Preliminary Drainage Report and Master Development Drainage Plan

Monument Ridge East

El Paso County, Colorado

April 2024

**D1**  
 sheet number

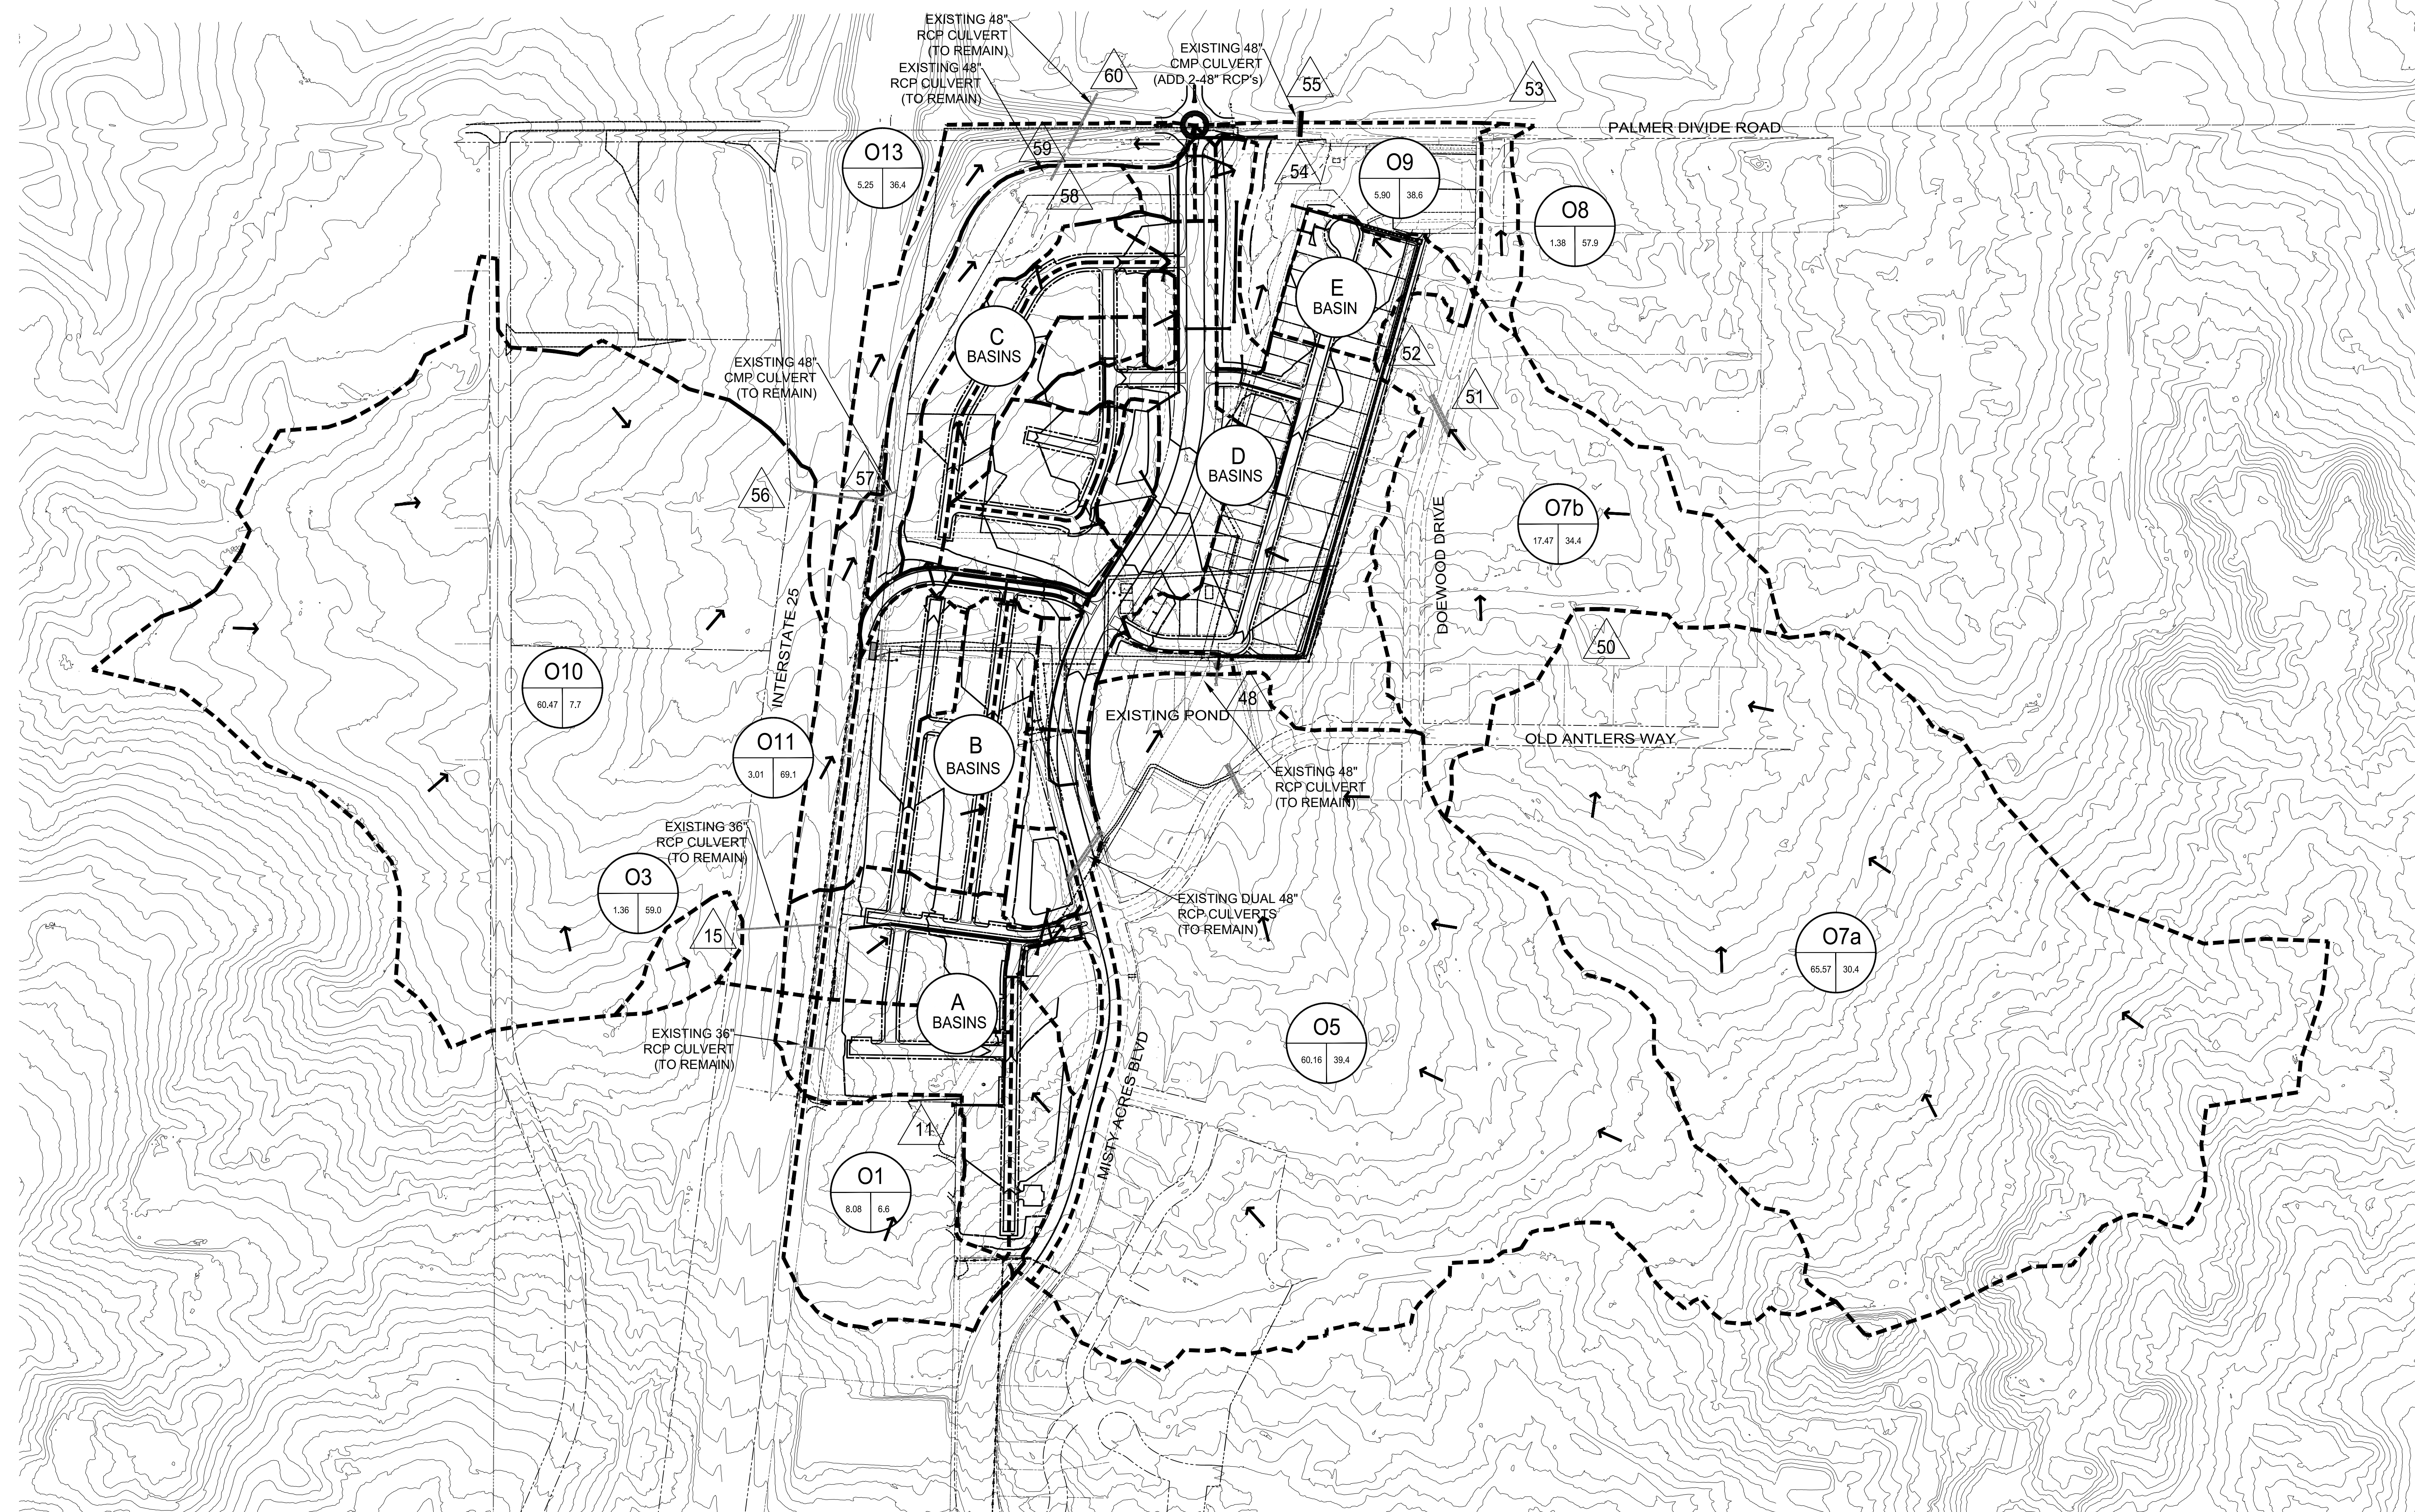
Please include the basin area and generated flows in the description of each basin.
Please include the final outfall location of the flow for each basin.

Please state whether the pipes run under Misty Acres Boulevard

Specify that this pond was designed/approved under EDARP Filing Number SF01016

Please state whether the pond will remain with upgrades or be removed.

Specify that this pond was designed/approved under EDARP Filing Number SF94003

For each basin, notate which WQ PBMP each basin is tributary to and/or which WQ exclusion applies. And/or just provide the WQ Treatment Summary Table I requested on the last page of this report.
